Your Ref: 2025/90420
Our Ref: A006851

Shaw Cross House, Shaw Cross Business Park, Shaw Cross, Dewsbury - Discharge of details reserved by Condition 10. (Sewerage Infrastructure) of permission 2023/93273 for Erection of two storey rear extension and extension to car park

Yorkshire Water objects to the discharge of condition 10.

(1-1) Through Foundation
ing Drainage

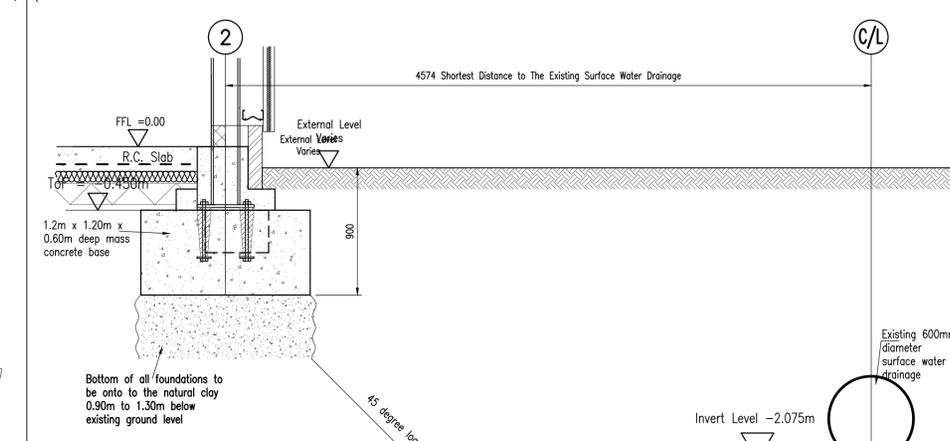
Drawing KS507/F01 (Rev C) dated 04/02/2025 prepared by Kryton Structures now shows Section 1-1 as the load spread being from the clay beneath the footing. Clarification is sought as to why Section 1-1 was from the footing base in the first place. Furthermore, the invert level of the 300mm diameter in Section 2-2 is unknown (TBC). The invert depth of the sewer at this location should be confirmed to allow a proper consideration of the supplied drawing.
